# CITY OF ALBUQUERQUE

RE: **Lot 16 Block 6 Unit 18, S.A.D. 228**  
**6512 Kimmick Dr. NW**  
**Grading and Drainage Plan**  
**Engineers Stamp Date 9-7-17 (D10D003M16)**

MICHAEL SANCHEZ - CRUZ & BRENDA - GRADING & DRAINAGE PLAN

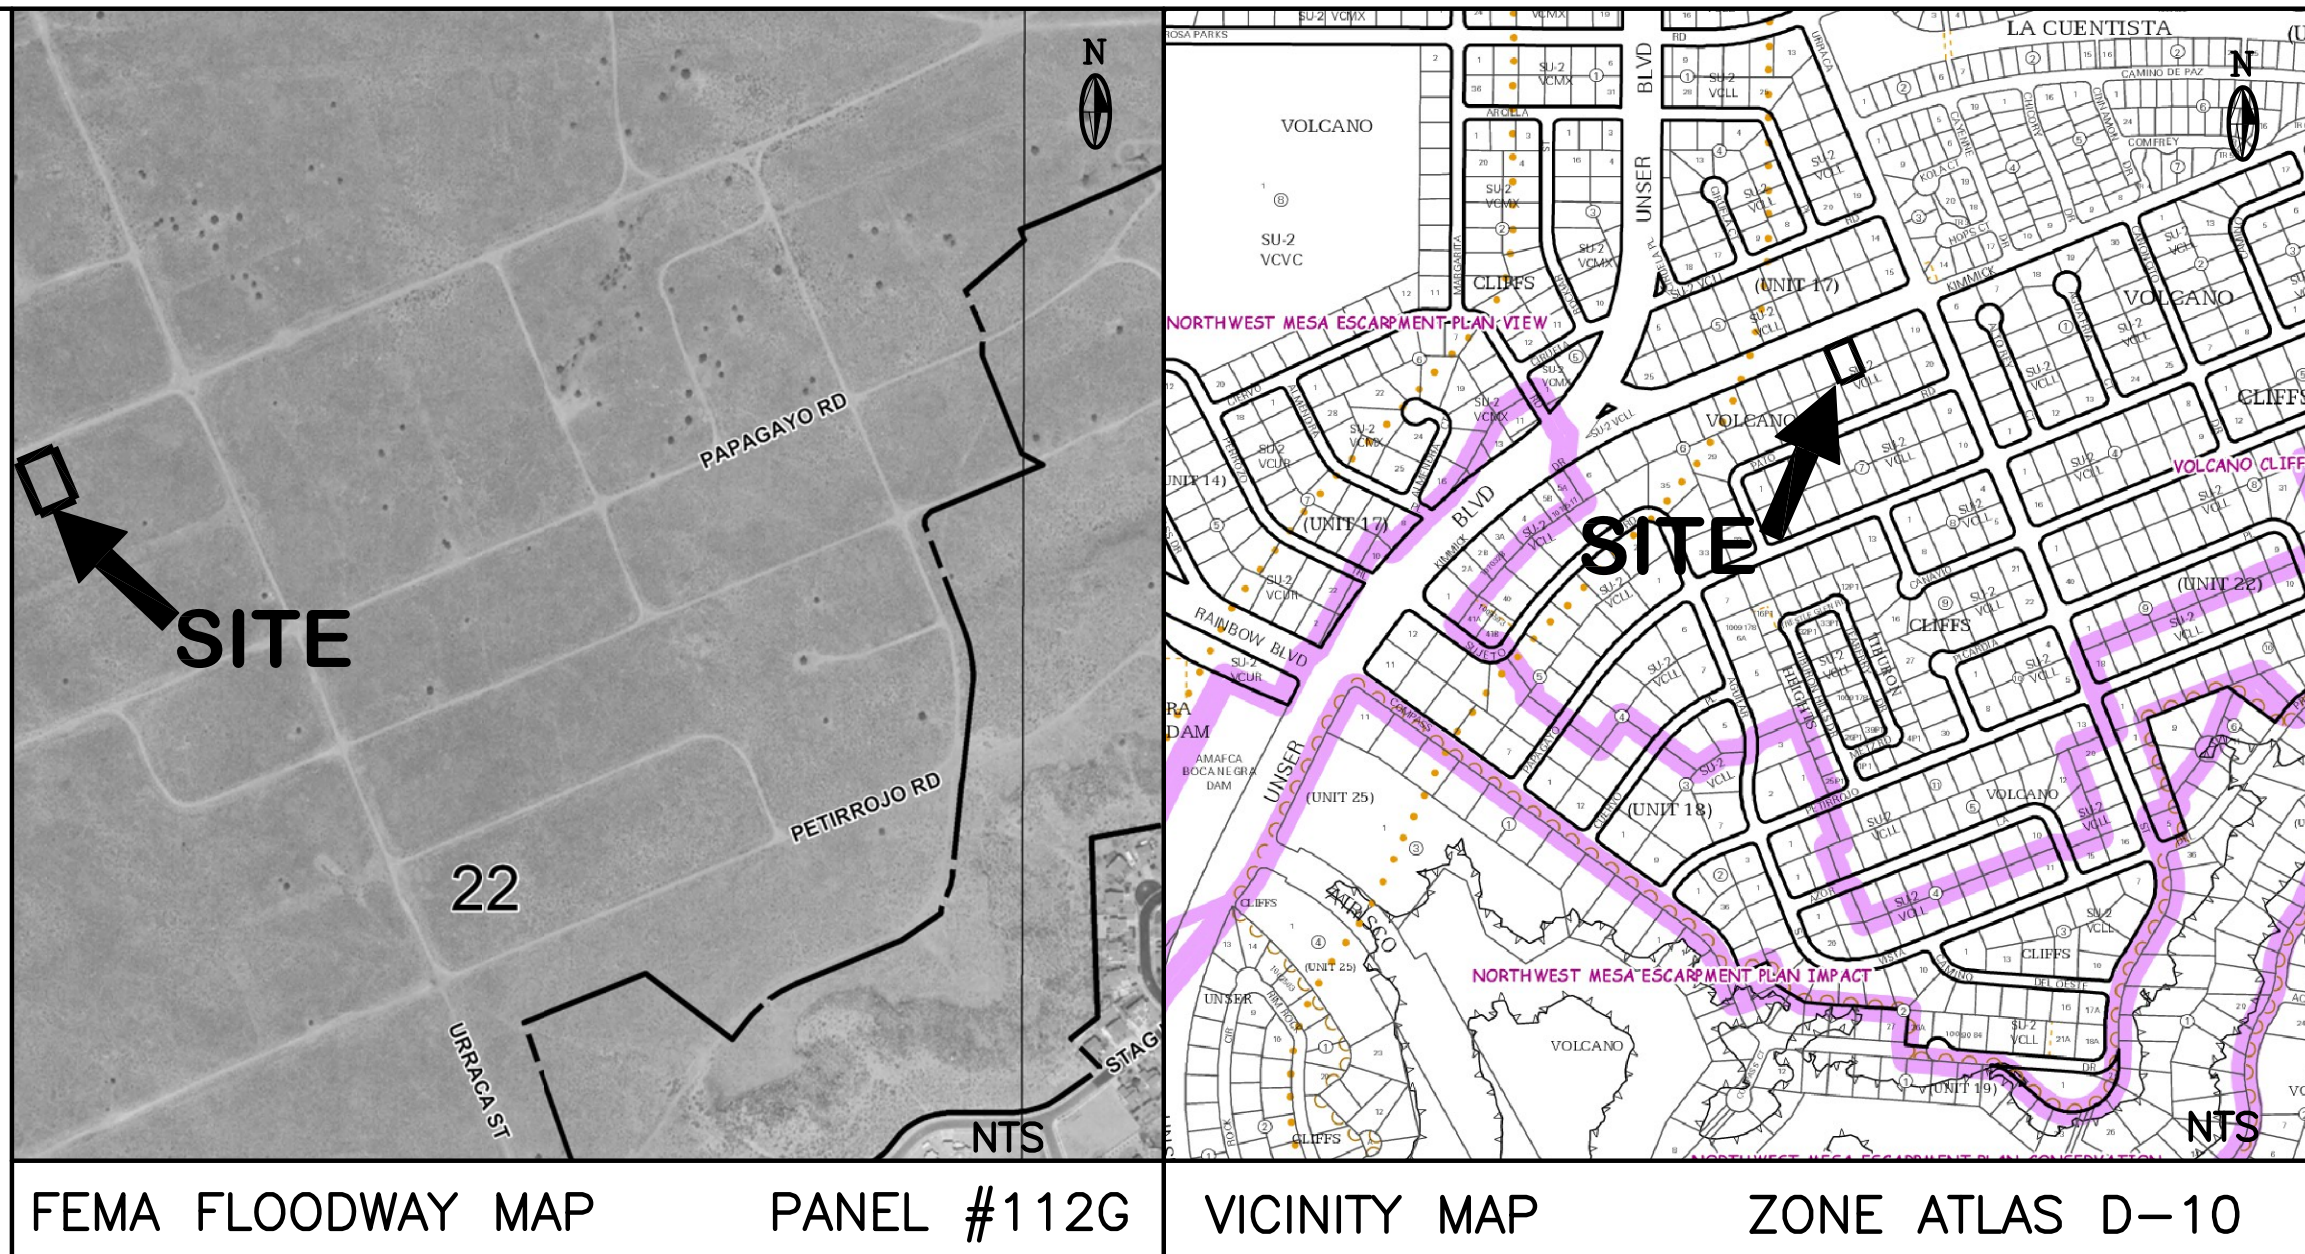
- Show the 7' PUE in the rear yard. Flows should travel from east to west in this area and out to Pato Rd.
